Please ask for: Ms Iqraa Malik
Email: iqraa.malik@terraquest.co.uk
Telephone: 01212341390
Our Ref: AW/184/21/HH
Your Ref:
Date: 17th May 2021

Application for Planning Permission for Works or Extension to a Dwelling

Development: Proposed replacement and enlarged front entrance porch
Location: 3 Nuffield Close Aldwick PO21 5RA

Block plan 1:500 @ A3

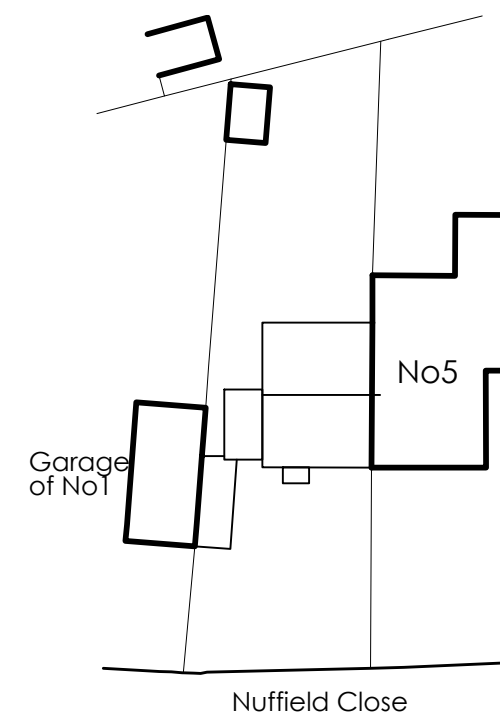
Dimensions: You are required to include dimensions on the block plan from the proposed extension to all site boundaries.
